CITY OF PORTLAND, MAINE

December 15, 2015

Project Name:	Portland Retirement Residence	Project ID:	2015-164
Address:	802 Ocean Avenue	CBL:	Map 411, Lot 7A,
Applicant:	Lenity Architecture and Hawthorne Development Group		Map 416, Lots, A -6,7 and 21
Planner:	Barbara Barhydt, Development Review Services Manager

**SITE PLAN**  
OF  
**PORTLAND RETIREMENT RESIDENCE**  
802 OCEAN AVENUE  
PORTLAND, ME

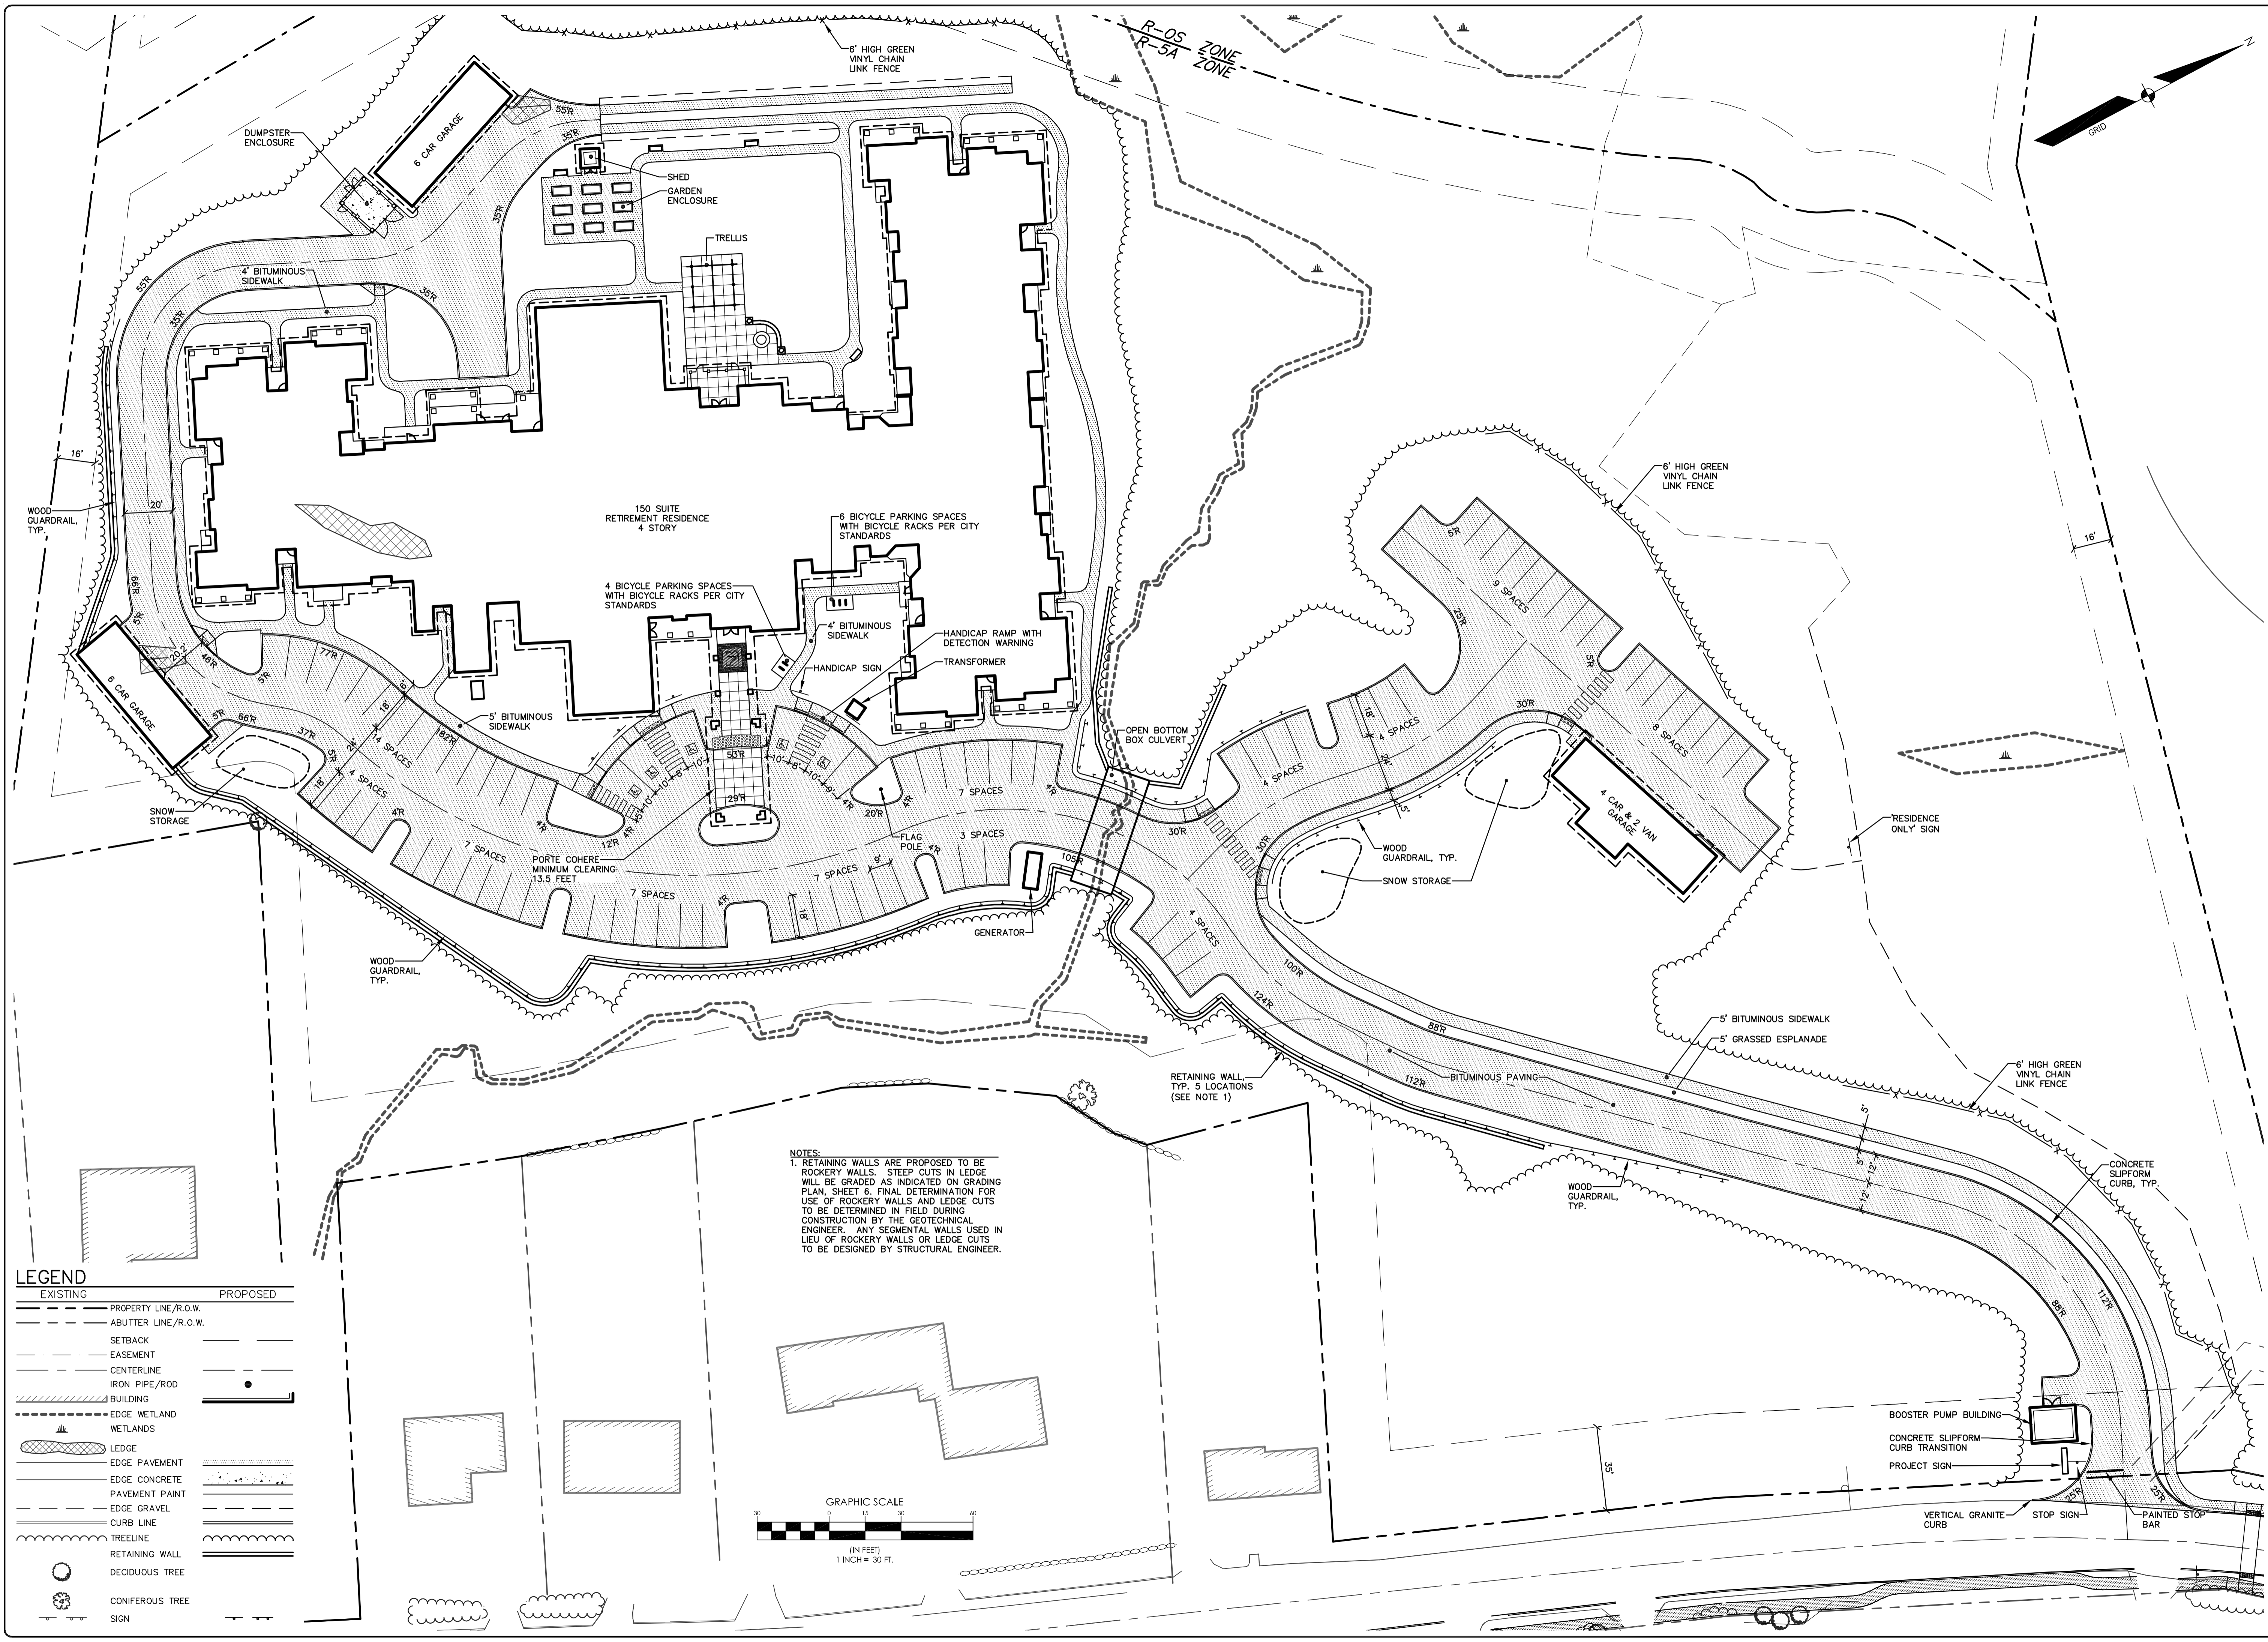
3. The applicant shall construct a crosswalk across Ocean Avenue that includes ADA compliant ramps, pavement markings and signs. The crosswalk shall be located between the proposed driveway and the driveway to Ocean Ridge. The applicant shall provide a plan for review and approval by the Traffic Engineer and Planning Authority.

4. The Ocean Avenue roadway width and alignment is not consistent in the area of the proposed driveway and the applicant shall revise the curb alignment design to provide a uniform roadway width. The applicant shall provide a revised plan for review and approval by the Traffic Engineer.

6. The applicant shall submit revised final grading plans that include a note or additional spot grades / flow arrows in the area of the proposed snow storage area near the southeasterly corner of the site to ensure that the finish grade is constructed to direct the water to the nearby catch basin (CB-3) to receive treatment in the subsurface sand filter for review and approval by the Consulting Civil Engineer. In addition, a revised final Landscape Planting Plan that takes into consideration the proposed snow storage locations be submitted for review and approval by the Consulting Civil Engineer and City Arborist.
